Inner Sydney high school
Response to Submissions - Architecture
NSW Department of Education

fjmt studio architecture interiors urban landscape community
04 October, 2017 - Document ref - Rev 01

West Elevation Building 2 Proposed
1:200

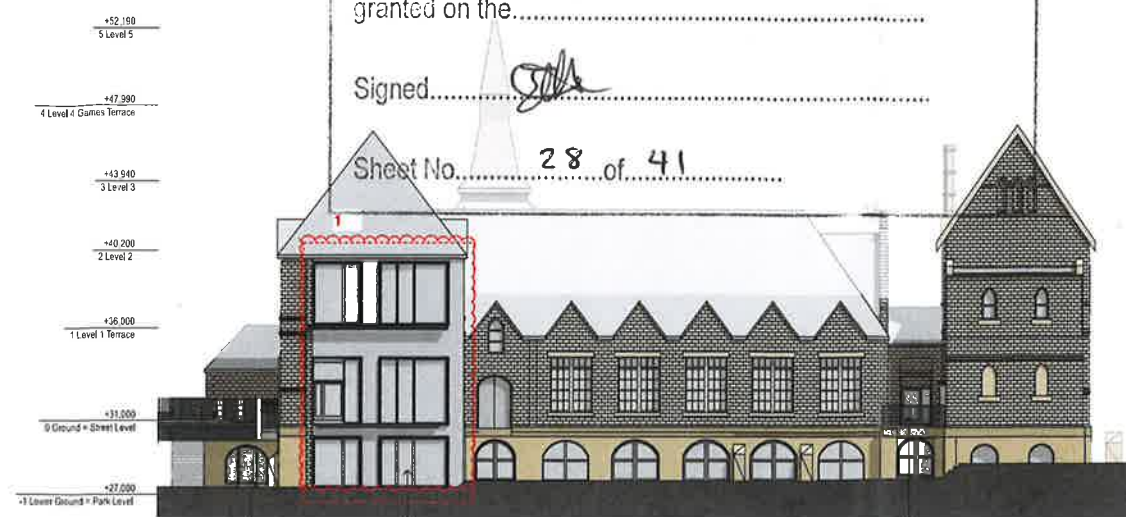
A: 220661_City of Sydney Submission_2017Aug17_1223	
3b	The openings left by the removal of the bridge walkways are proposed to be retained and glazed. This is not supported. As the heritage buildings are highly intact except those later interventions and the facade containing those openings are highly visible from the streets, the original openings and joinery should be reinstated.	The openings left after the removal of the walkway will be expressed as new insertions into the existing fabric. As this site has always been a school, it is important that the layering of the site is understood. The design response will be a similar approach to the new openings developed by fjmt for the Mint on Macquarie Street for Sydney Living Museums. Refer Image 3b
3c	Existing palisade fence on the southern boundary is not highlighted in the plans and HIS report. The fence is the remnant of the old fence of Prince Alfred Park. It is to be retained and incorporated in the design.	The existing palisade fence on the southern boundary will be retained. A new 500mm high flood mitigation wall will be located to the inside face of the fence plinth.

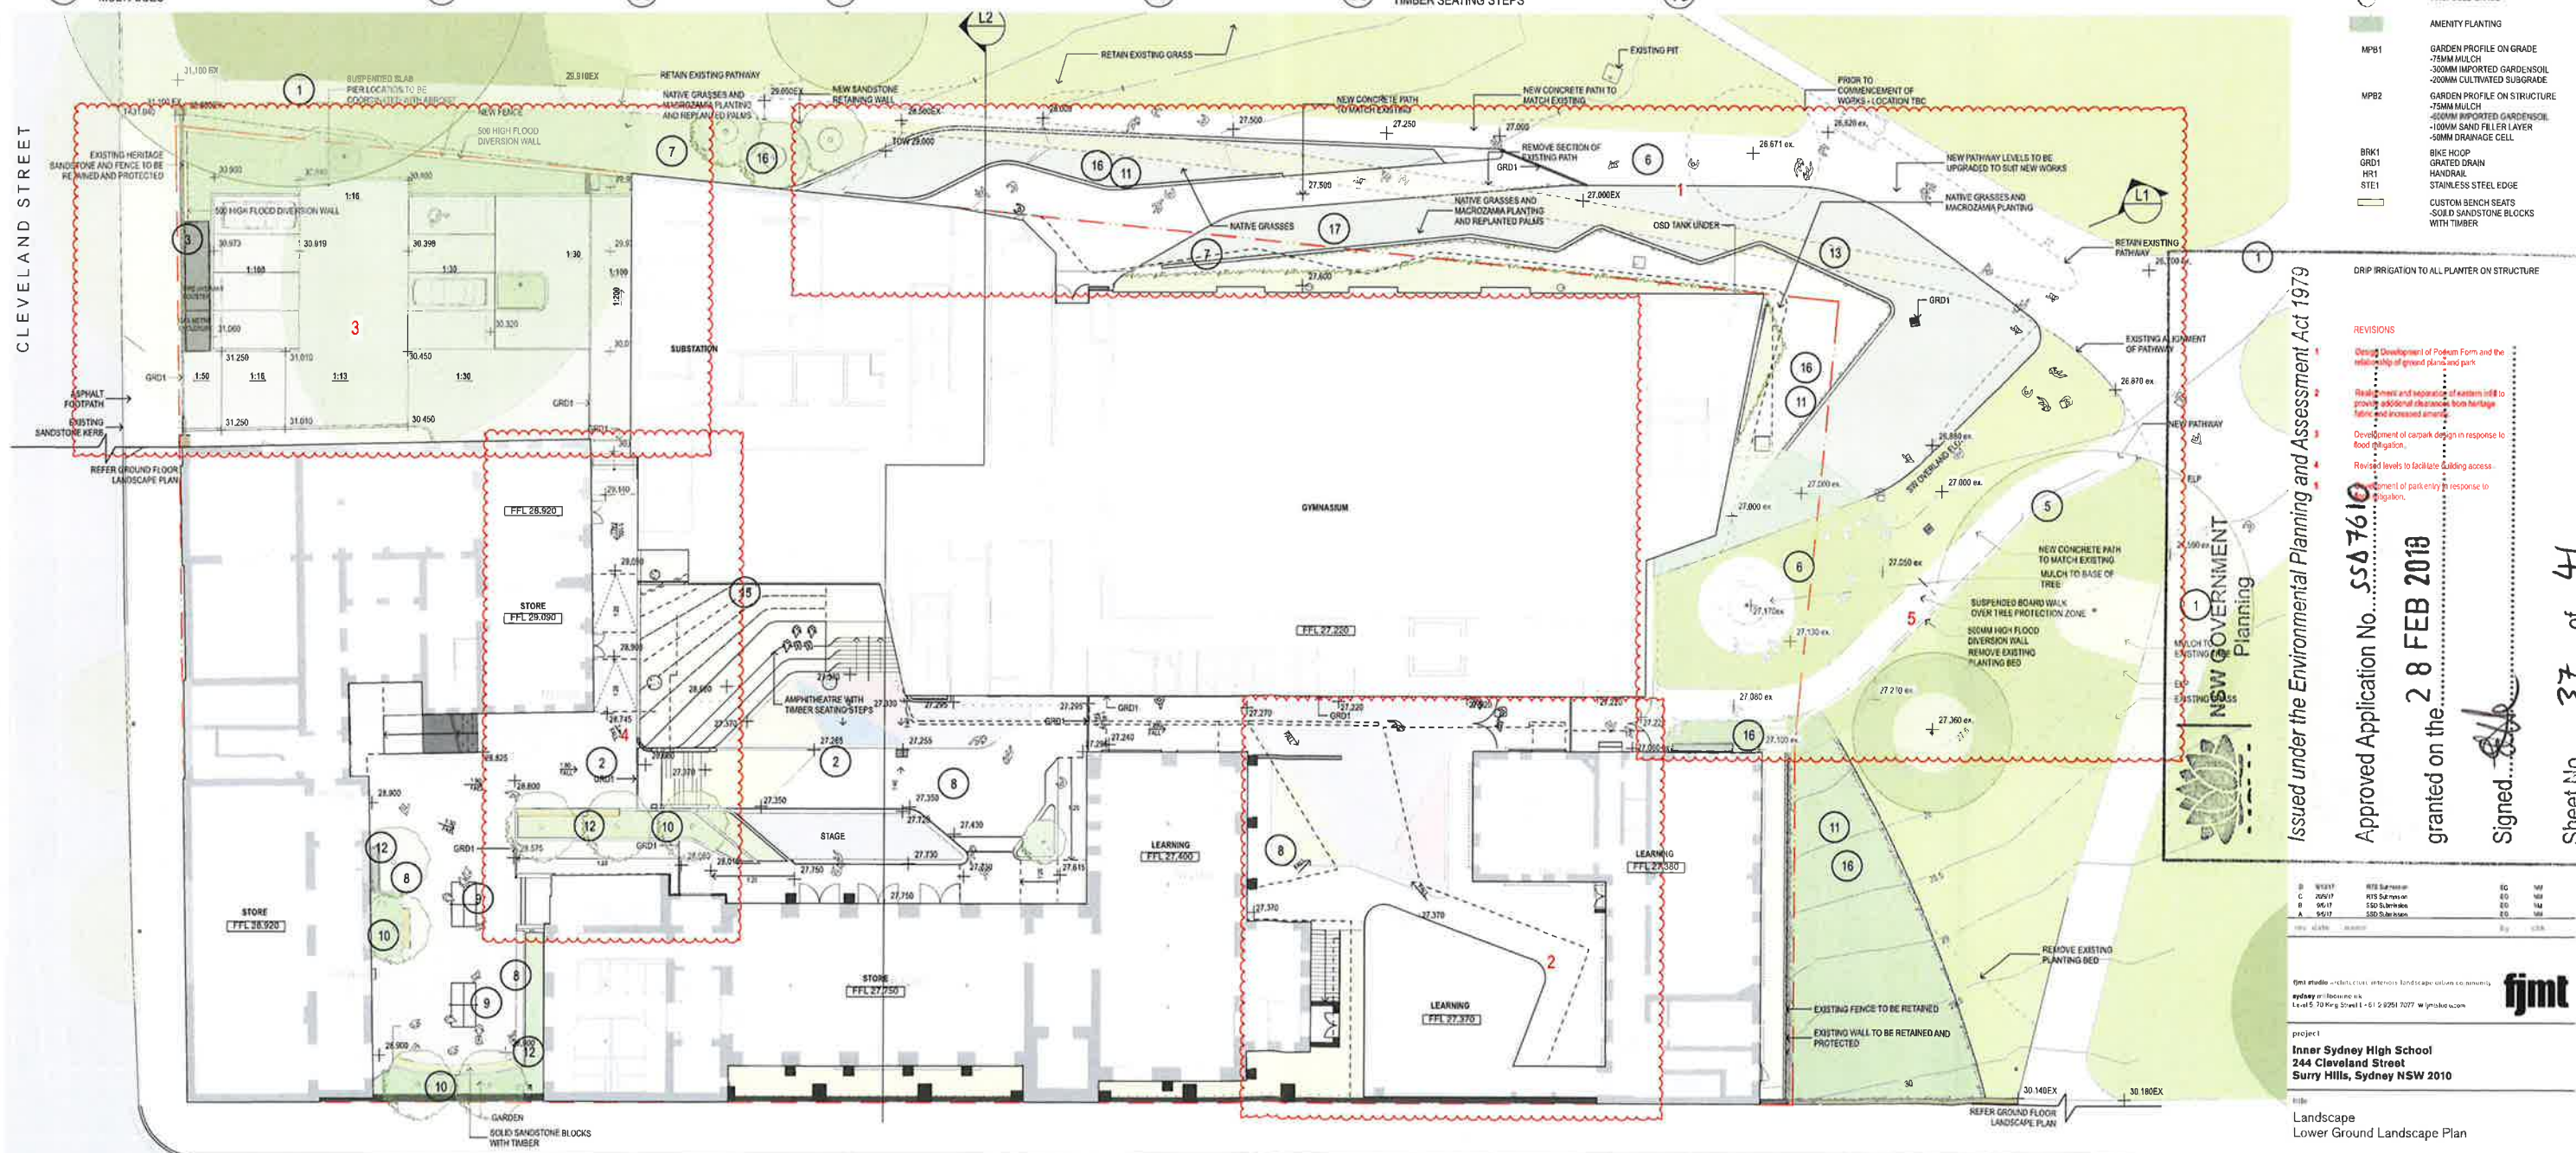
The two most significant landscape issues lie with the interface between the school and Prince Alfred Park and the intensification of use of the park itself. Both of these issues are in effect 'cross jurisdictional', being the concern of the project landscape design and Public Domain and Parks team within the City. While these have been discussed between the relevant parties, the following issues remain:	
19a	Park Interface	
	The proposal introduces two new pedestrian connections from the school to the adjacent park. Although the provision of access is supported in principle, the proposed layout results in two paths and planted buffers that extend well beyond the school boundary, effectively commandeering substantial sections of the park. The length and form of both paths is well beyond that required to give students access, and creates spaces that facilitate student use rather than welcoming the public. For example, the path leading from the northern boundary of the school widens out to create a gathering space around the existing tree on site, then narrows again before connecting to the park path network. This gathering space is positioned partly within the school and partly within the park, but the narrowing of the path signals to park users that this reads is a school space rather than a public space at present.	Refer to 8001 Lower Ground Landscape Plan

West Elevation
1:200

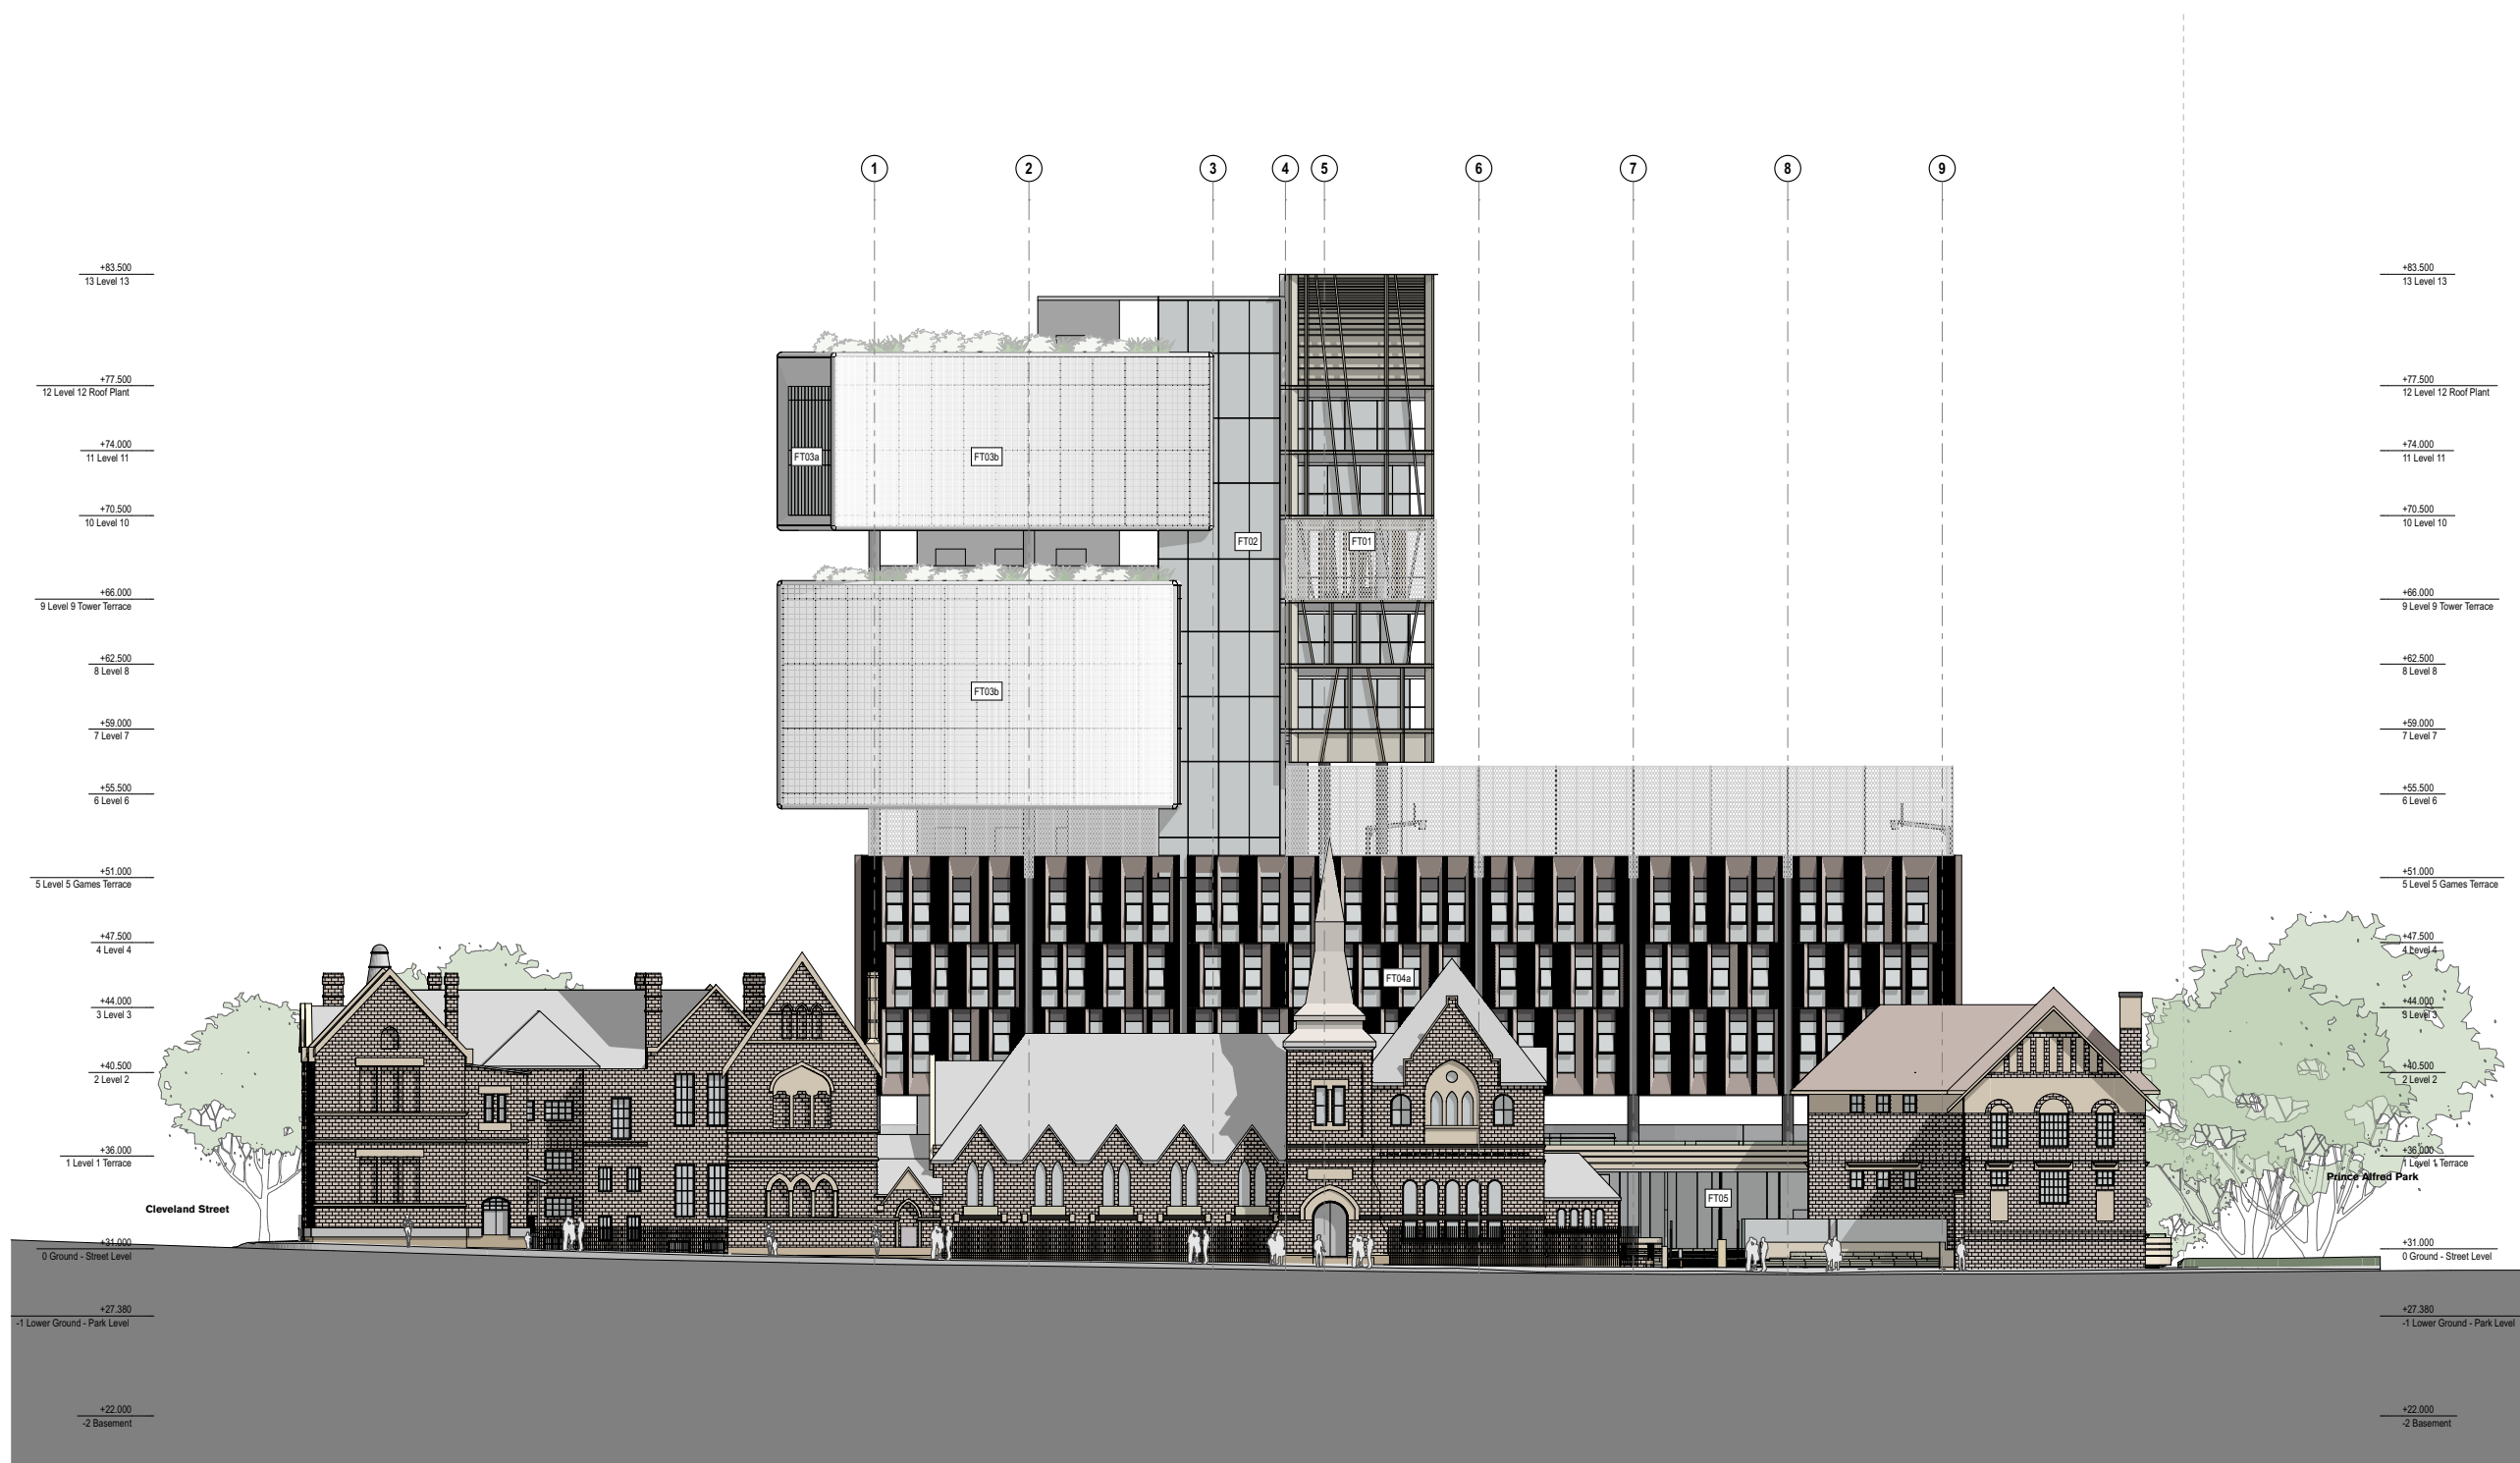
A: 220661_City of Sydney Submission_2017Aug17_1223	
8a	A physical detail materials samples board is required. In addition, detail part elevations may be required to clearly communicate the design intent.	Refer updated Elevations
8b	In general, the Facade Types Legend on the elevations and the detailed submission on pages 41-48 of the ADS does not provide adequate information to clearly communicate the proposed materials, finishes and colours for all components of the facade, as follows:	Refer updated Elevations
8c	FT02: Additional consideration should be given to reducing solar gain to the east and west elevations of the stairwell facade, currently proposed to be fully glazed with high performance glazing and no external sun control devices.	The glazing will be high performance glazing with a dark interlayer to form a shadow.
1w 1	FT03b: The material submitted is extensive, but does not specify a colour or finish to the perforated aluminium shading screens. Reflectivity is a consideration for these large areas of the facade.	The finish for the perforated aluminium sheets will be a white PVF3 finish. Refer attached sample board.
